From: Amber Willard
Sent: 13 June 2025 10:20
To: Planning.Responses
Subject: FW: lu/77/25/pl
Attachments: E-002A-Existing Floor Plans and Elevations.pdf; P-001A-Proposed Floor Plans and Elevations.pdf; action sheet lu-77.docx

LU/77/25/PL at River Road.

Dwg. No. E-002A
 Title: Existing Plans and Elevations
 Address: 49 River Road, Littlehampton, BN17 5BZ
 Client: Mr A Smith
 Scale: 1:100@A3
 Stage: PLANNING
 Drawn: PS
 Date: April 2025

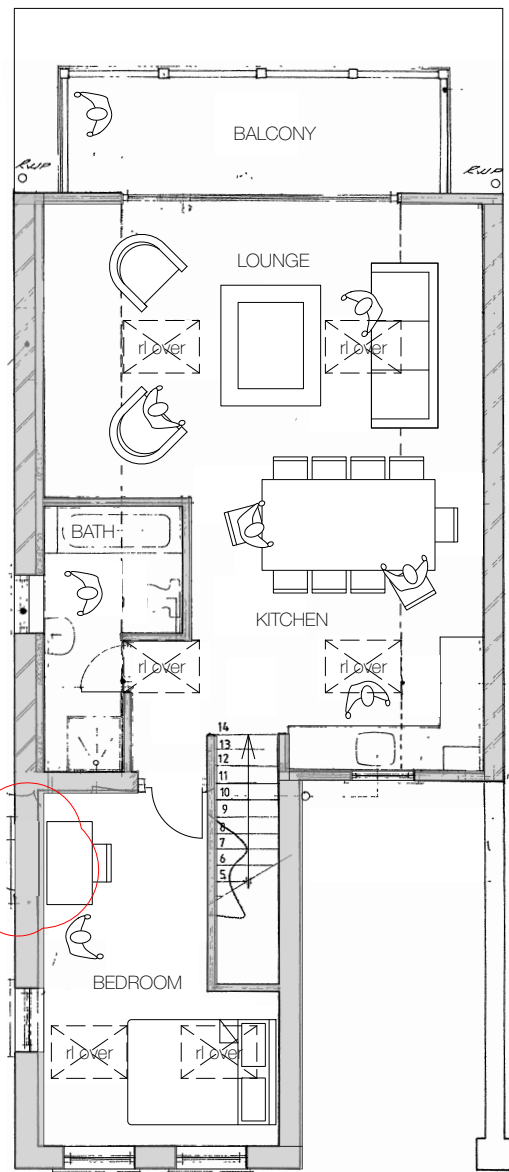
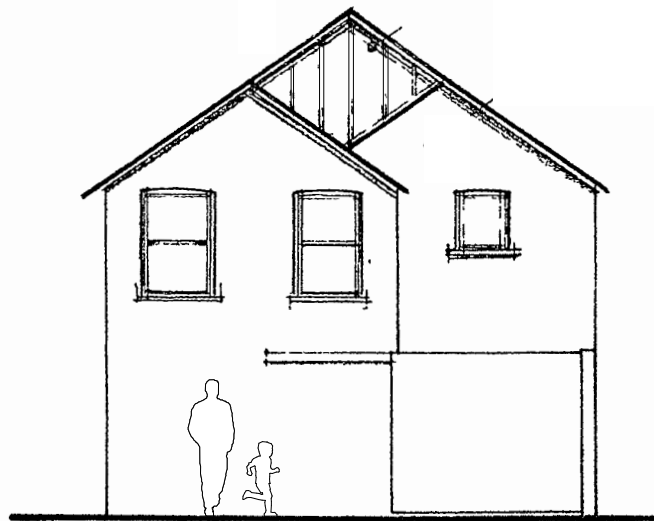
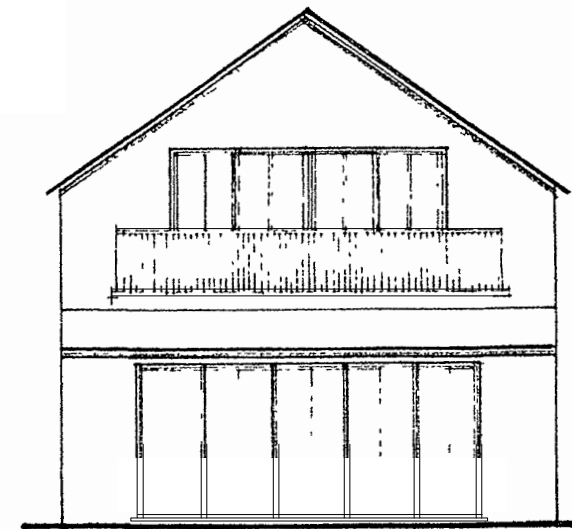
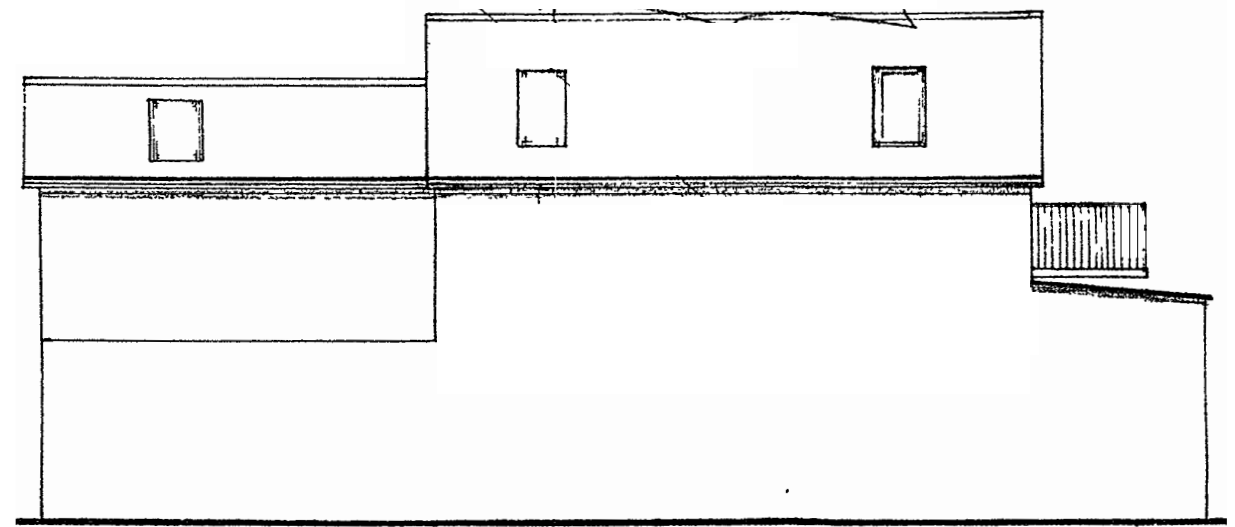
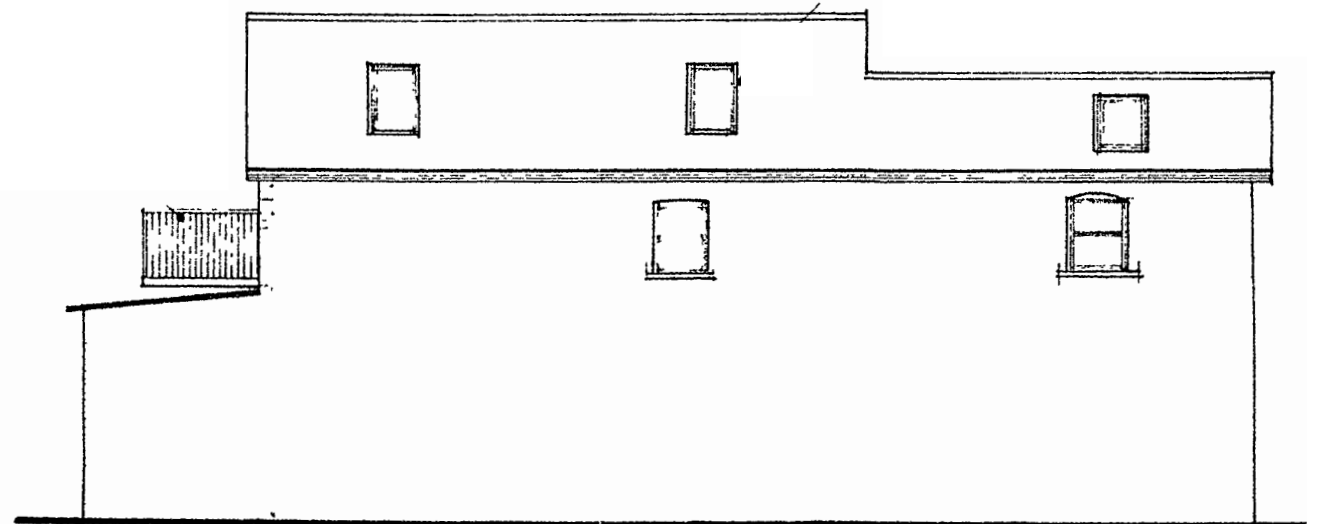
I have just passed LU/77/25/PL through to manager however have noticed that a window is on the floor plan but not shown on the elevations. (For both the existing and proposed)

Snippets of the plans below with the window in red on the floor plan but not on the elevations. Please are you able to amend the plans so the elevations match and I will get them substituted.

Thank you for your comment, please find attached the revised drawings.
